Greater Manchester Ecology Unit
Dukinfield Town Hall
King Street
Dukinfield
Tameside
SK16 4LA

FAO Principal Planning Officer
 Planning Services
 Ribble Valley Council

Your ref : 3/2025/0180
Contact : Derek Richardson
Date : 14th April 2025

Application 3/2025/0180 Proposed creation of an alternative temporary park and ride and heavy goods vehicle marshalling area facility associated with the Haweswater Aqueduct Resilience Programme (HARP), Land to the west of the A671 Pimlico Link Road

**TYPICAL CLOSE  
BOARD FENCE DETAIL  
(SCREEN HOARDING)  
1:25**

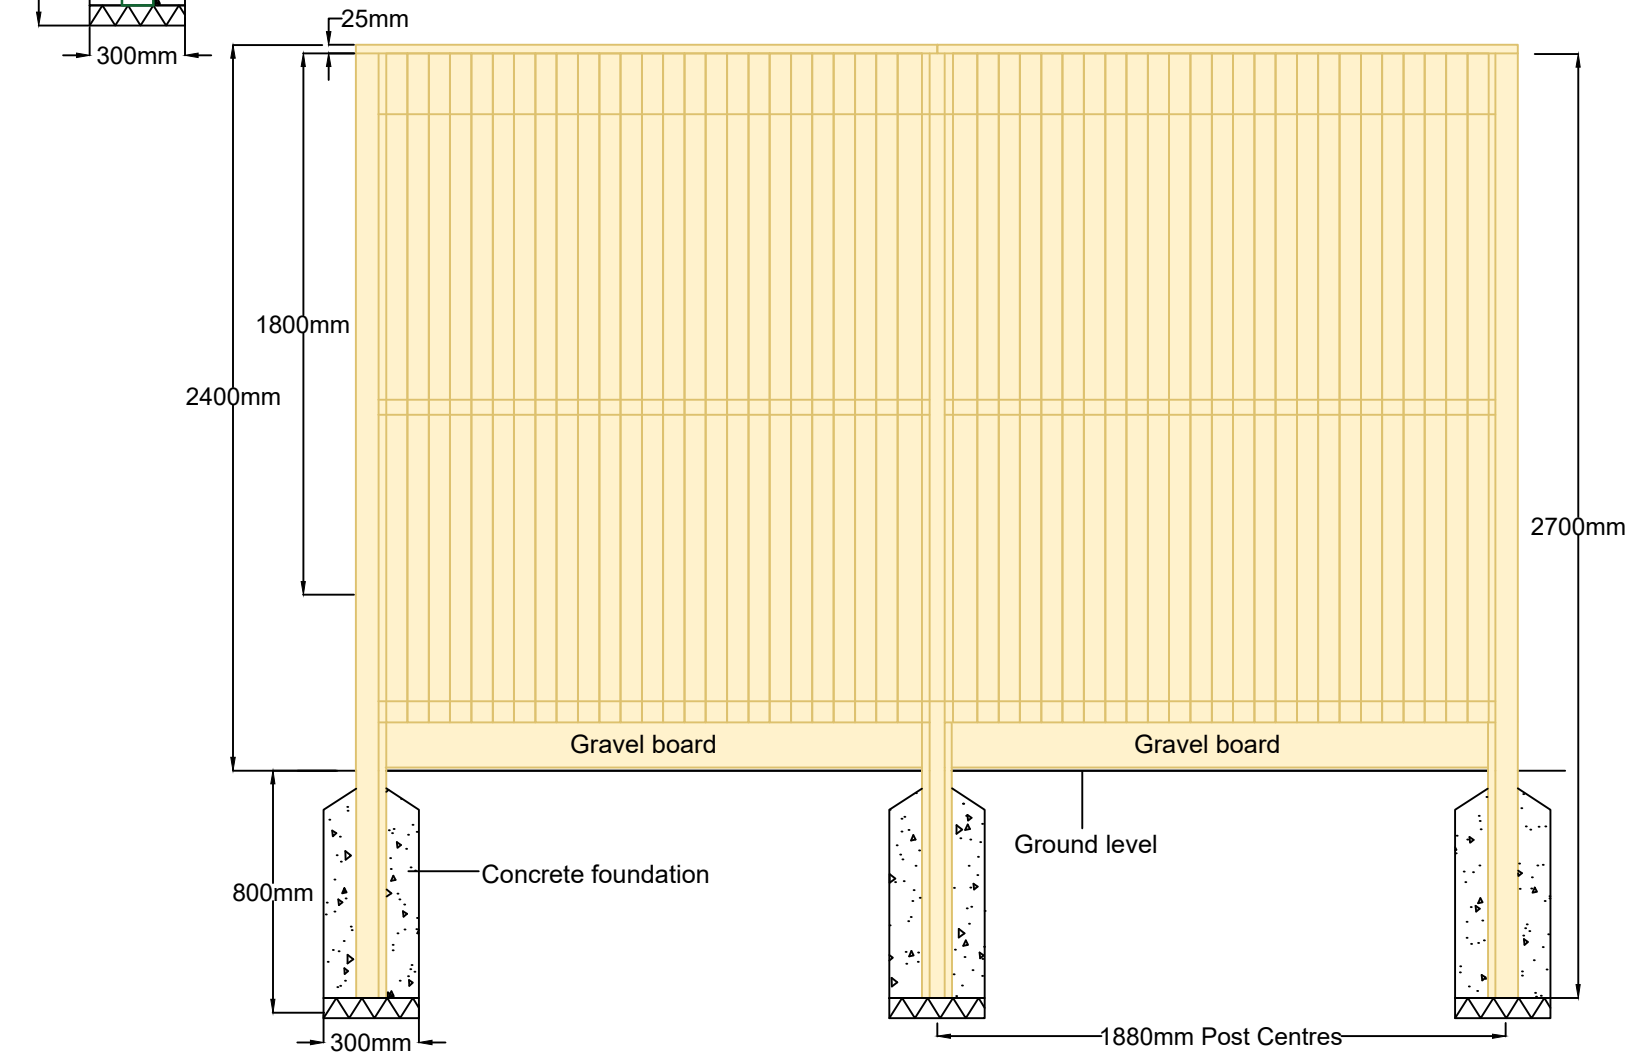
- The robust close-board fencing proposed along the northern boundary of the application site and separating the application site from the sensitive designated sites should be required to be installed prior to the commencement of the main construction works,
- A Biodiversity Construction Environmental Method Statement should be required to be prepared giving full details of how any potential impacts arising from the construction of
